National Highways Planning Response (NHPR 24-02)

Council's Reference: AL/11/24/OUT

Location: Land East of Westergate, Westergate

National Highways Ref: NH/24/05130

2019 Baseline Traffic Flows
AM Peak

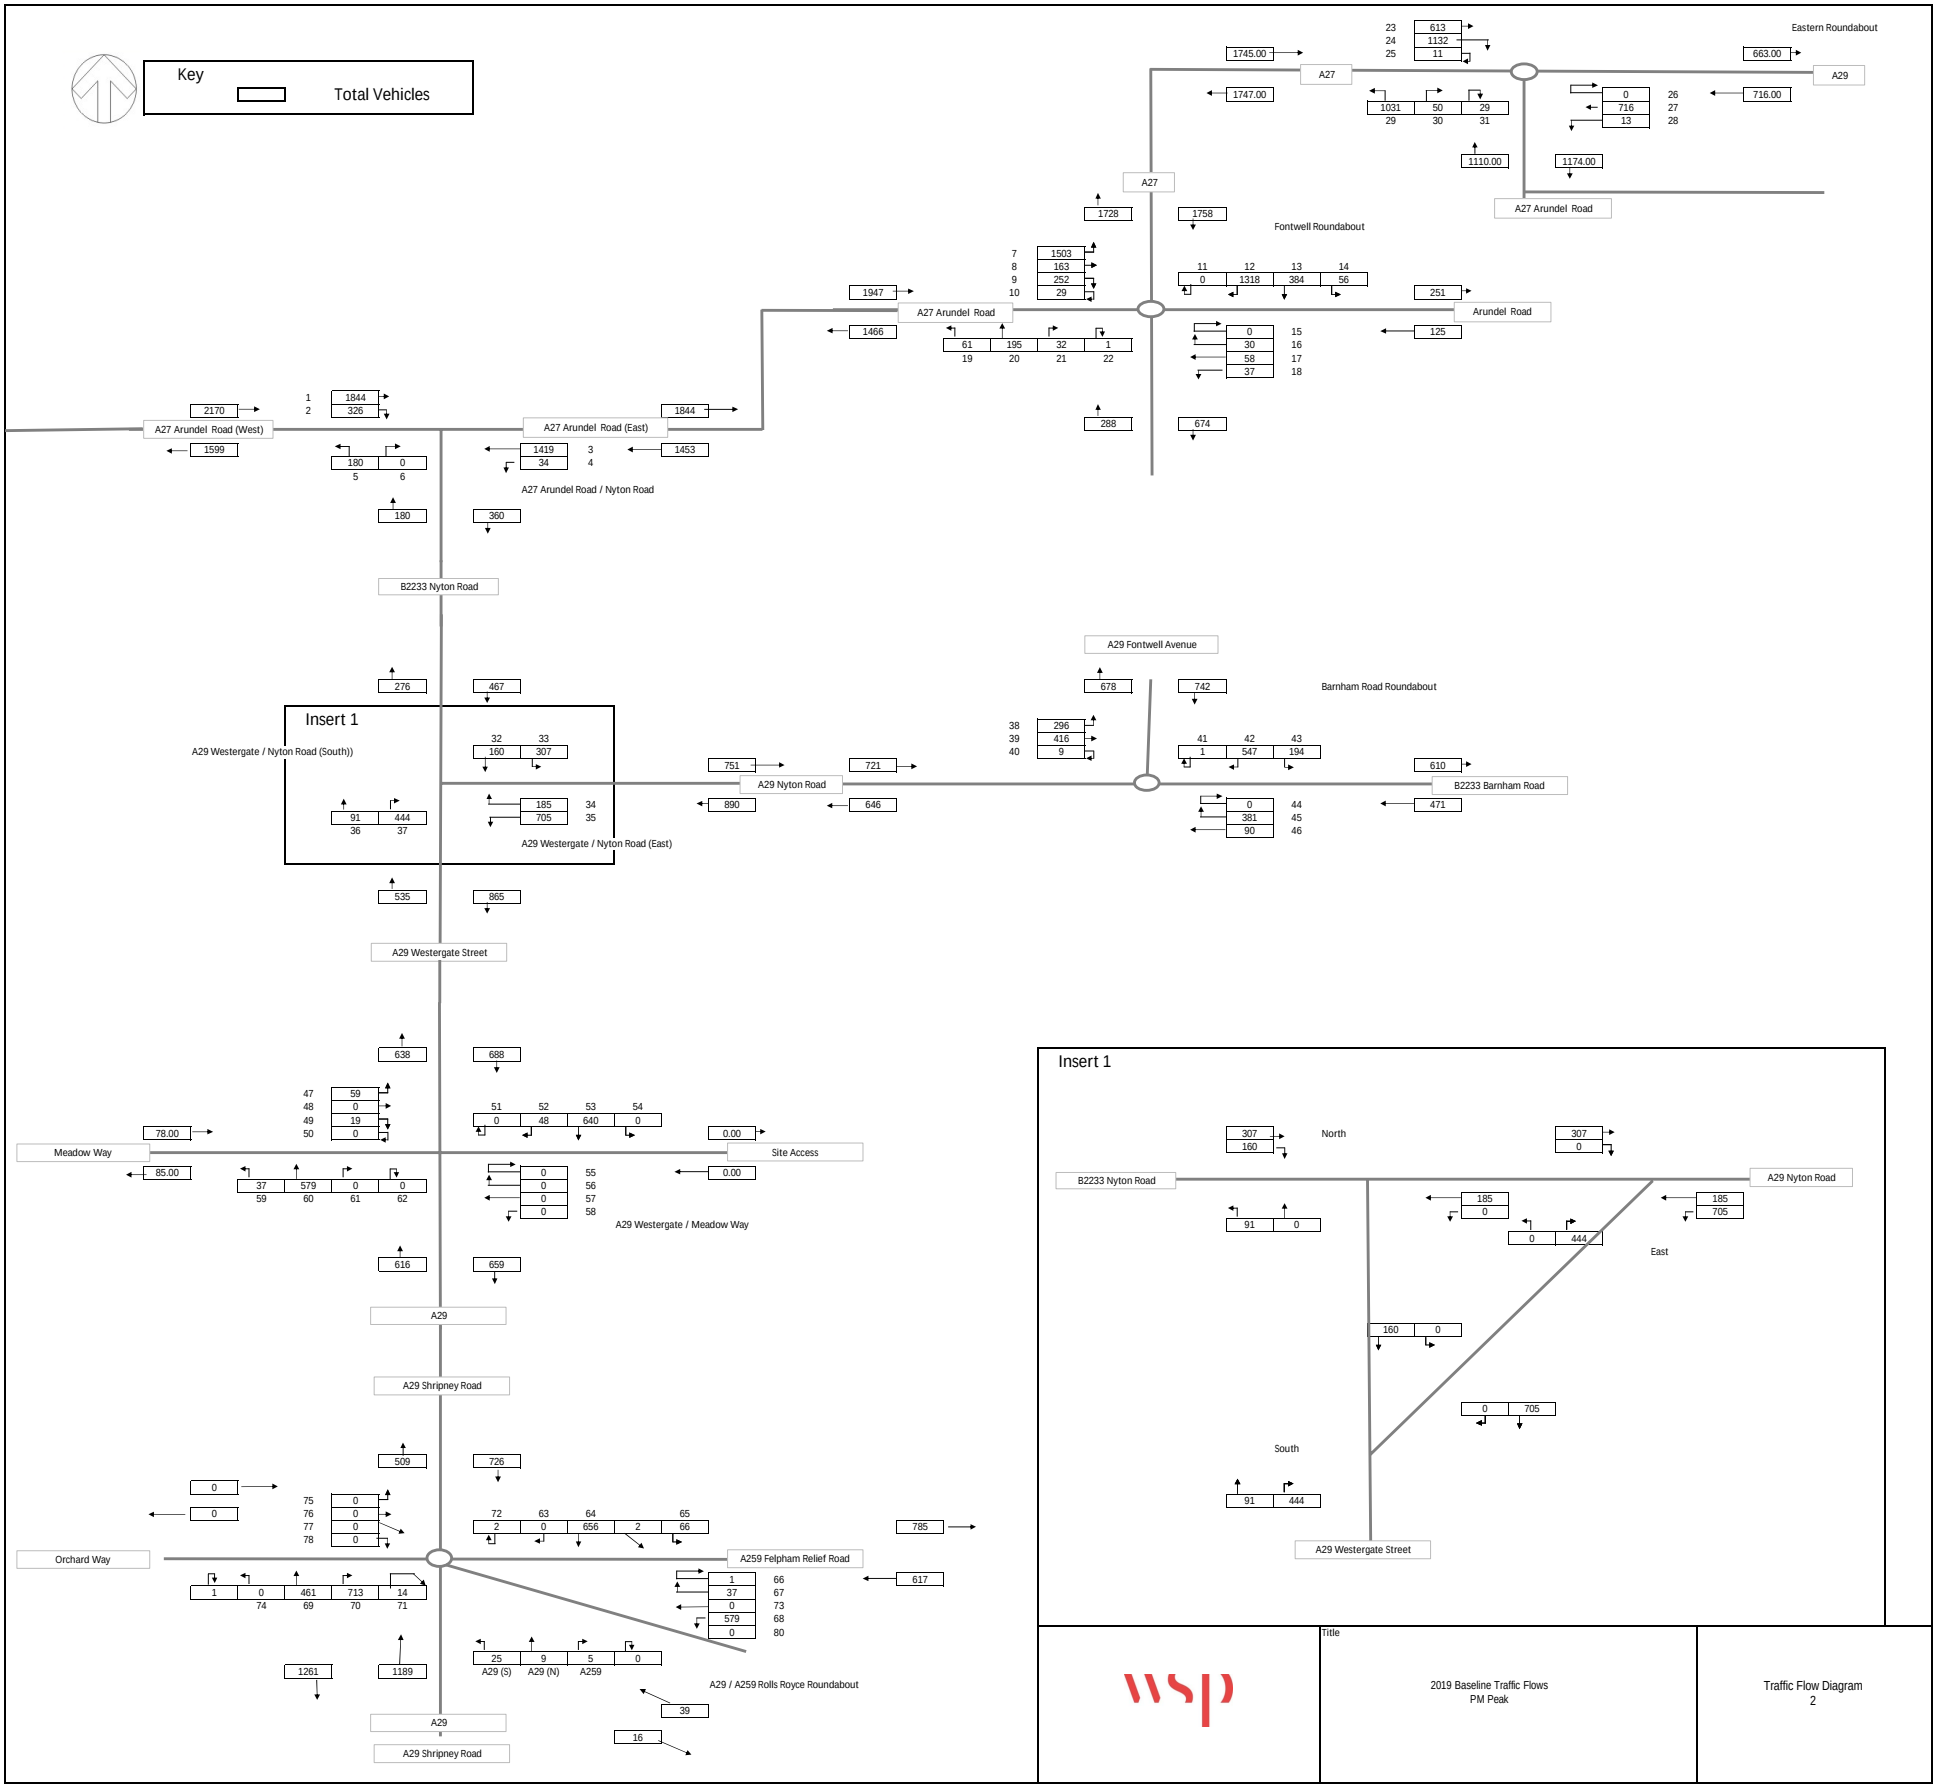
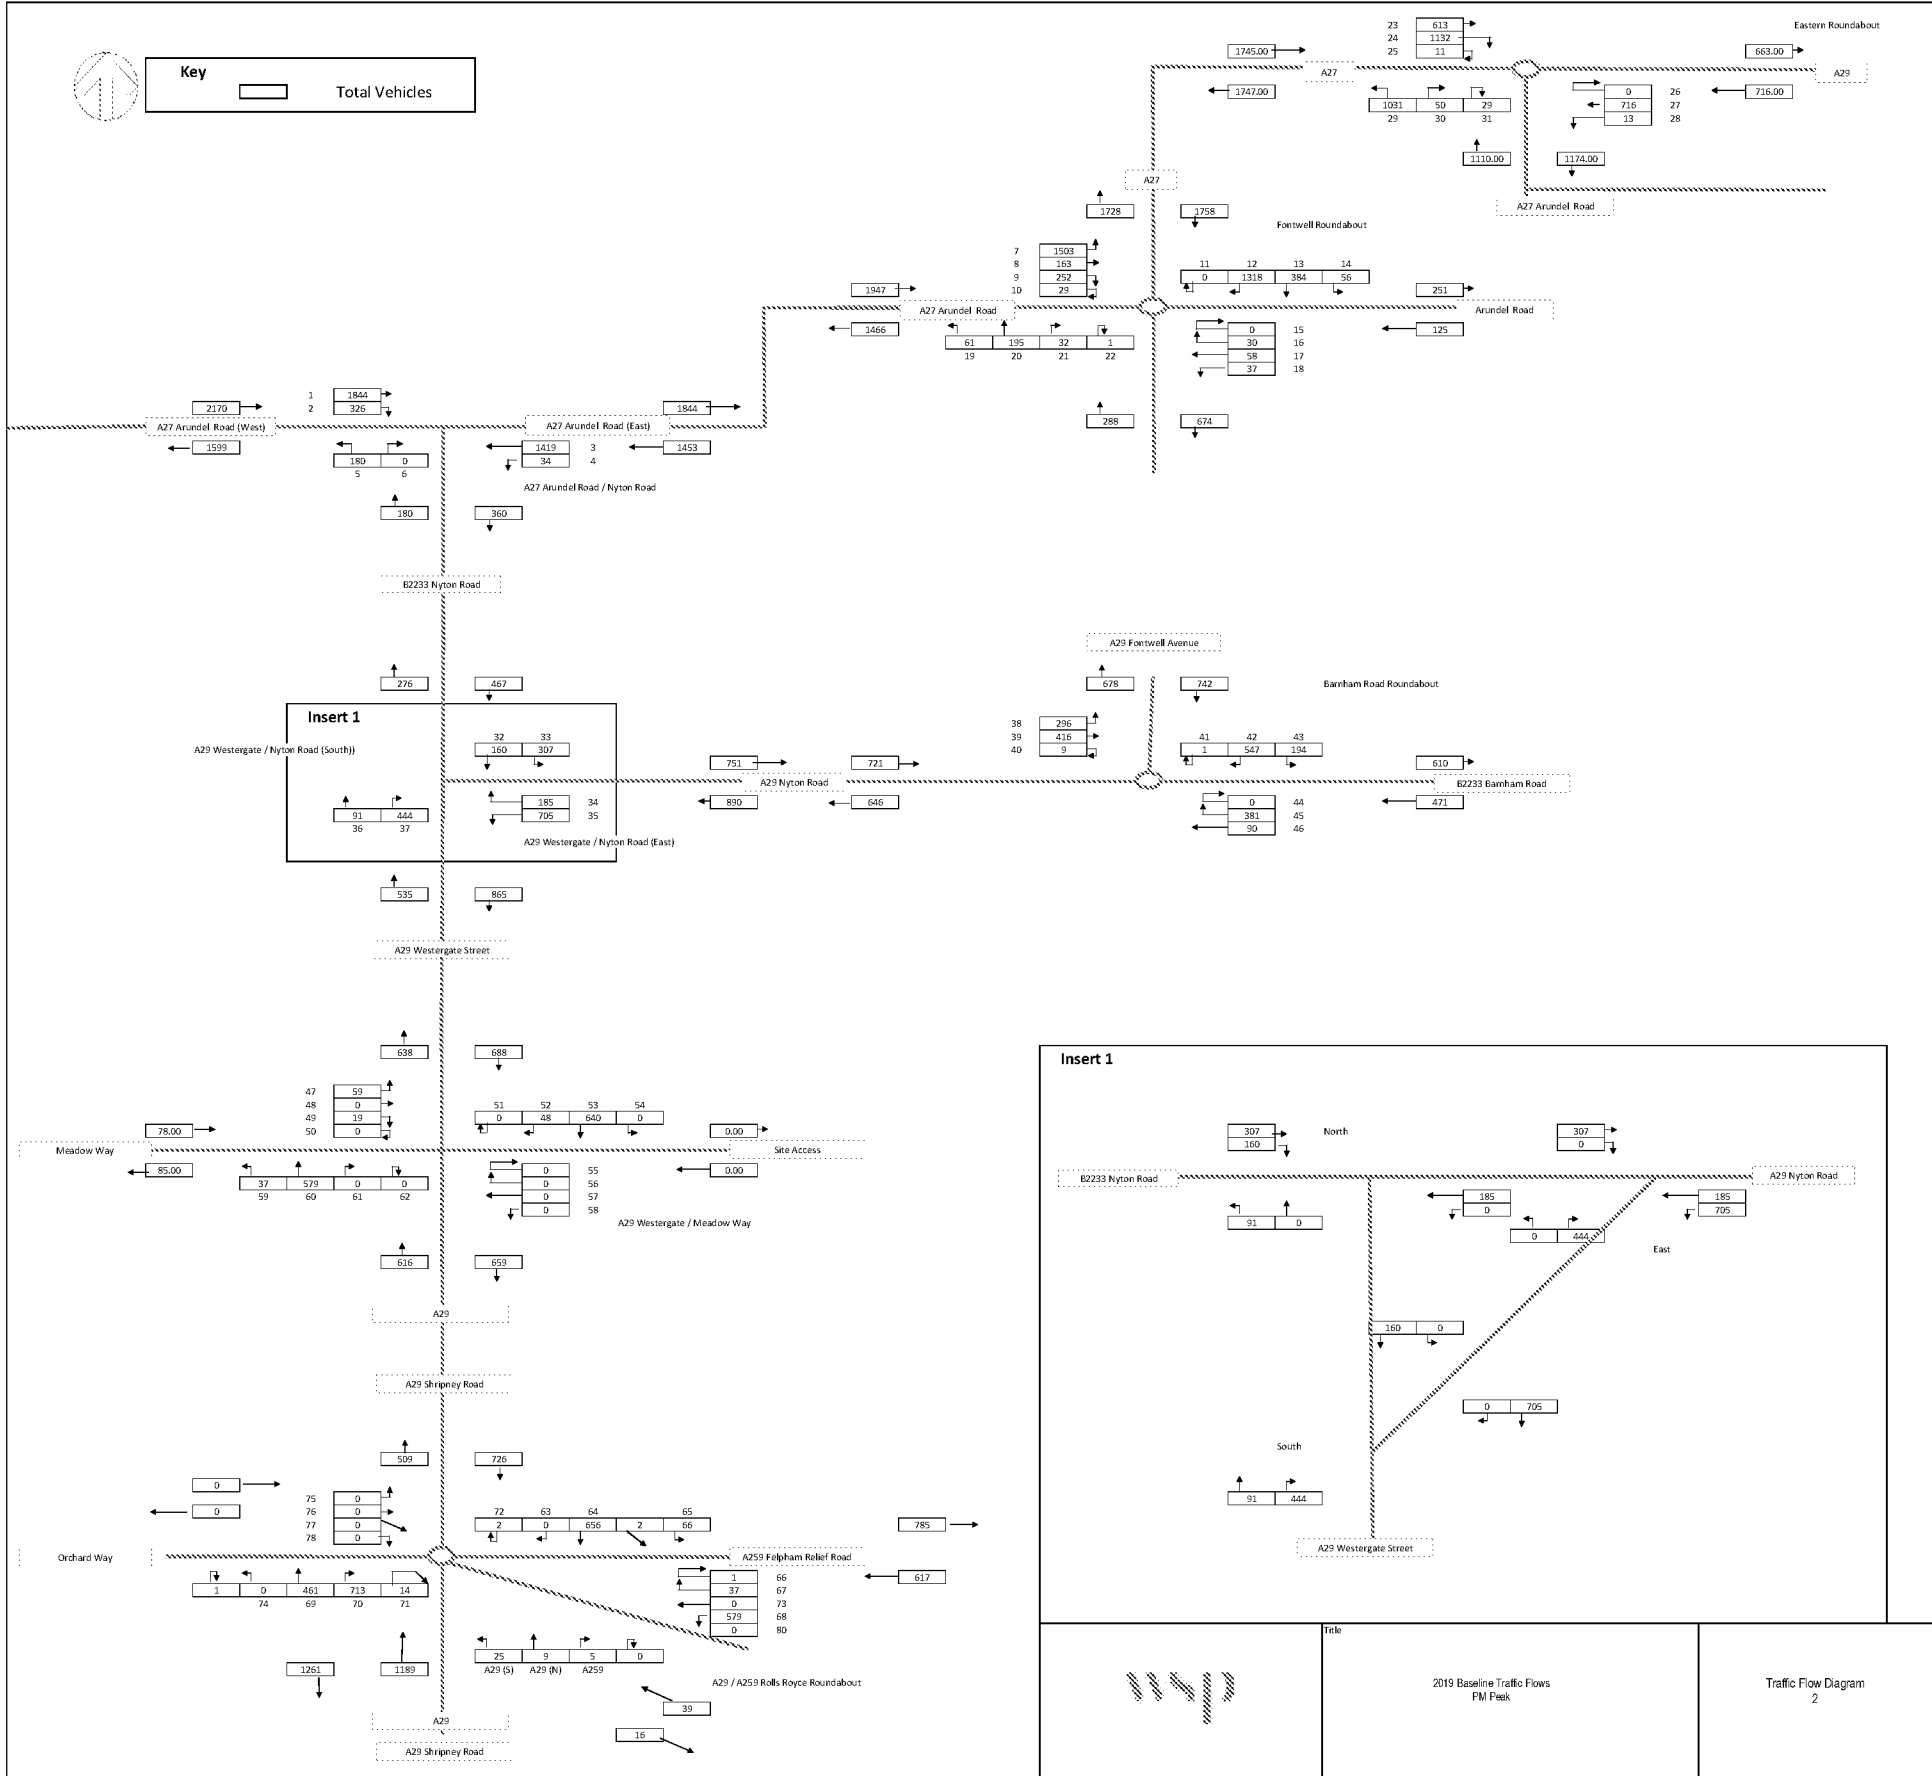
- 2019 Baseline Traffic Flows AM/PM – **how was this derived from CATM, please provide details**
- 2031 Do Minimum Traffic Flows AM/PM – derived from CATM, confirmed to be consistent with BEW Parcel SC1 TA

Figure 7-1 - A27/ A29 Eastern Roundabout Improvement Scheme

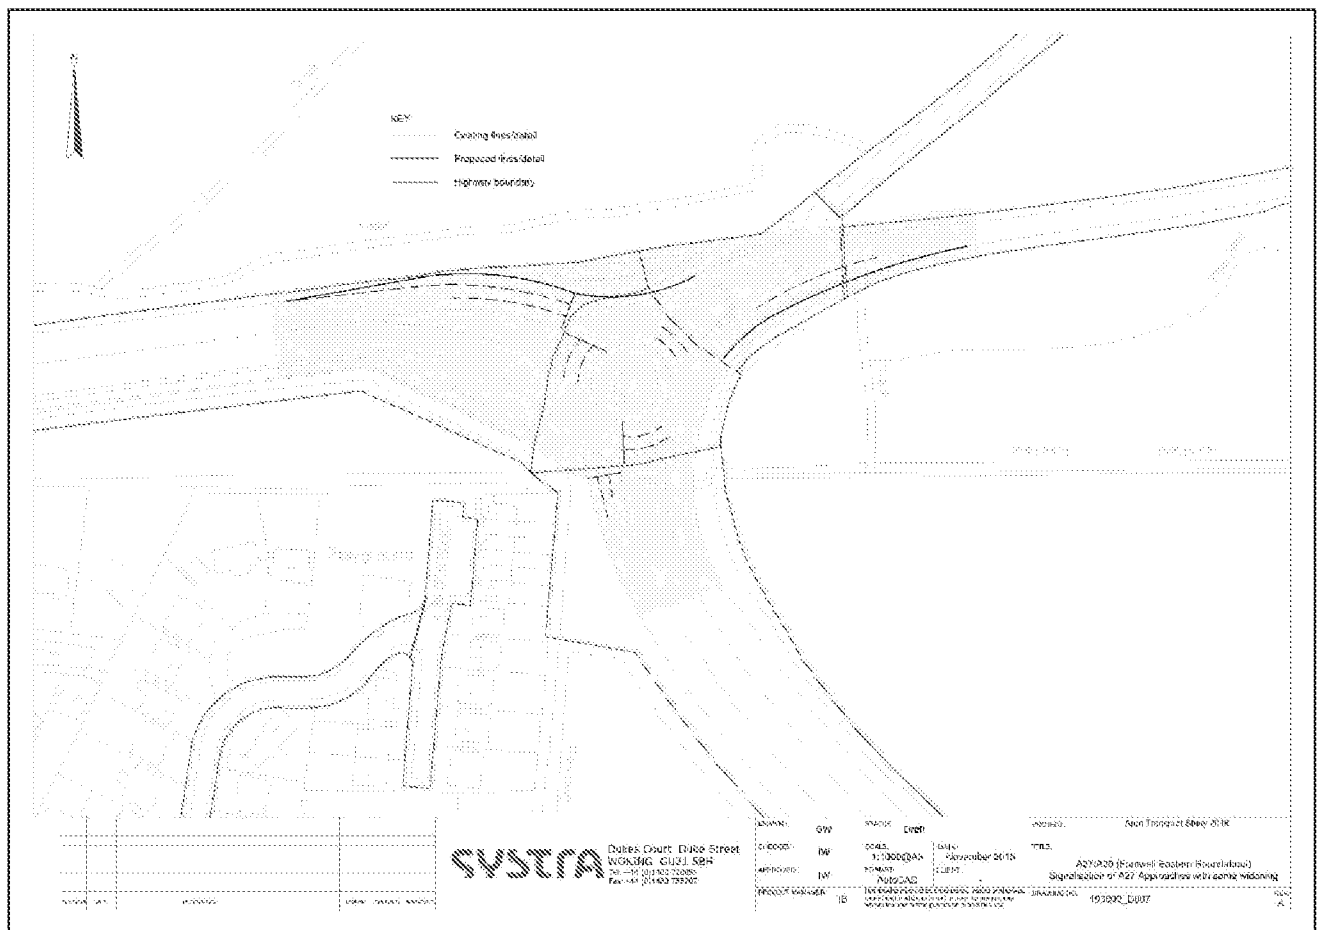
- Geometry has been reviewed and we note the following:
 - **The geometry figures are not clear in the submitted PDF; hence clarifications are needed**
 - **Assessment appears to have been undertaken based on existing geometry, the report text noted that at para. 7.2.4 that the 2017 Enterprise Bognor Regis Transport Review (EBRTR) mitigation has been considered ‘only where the existing layout is forecast to operate close to capacity or over capacity’ therefore clarification is required**
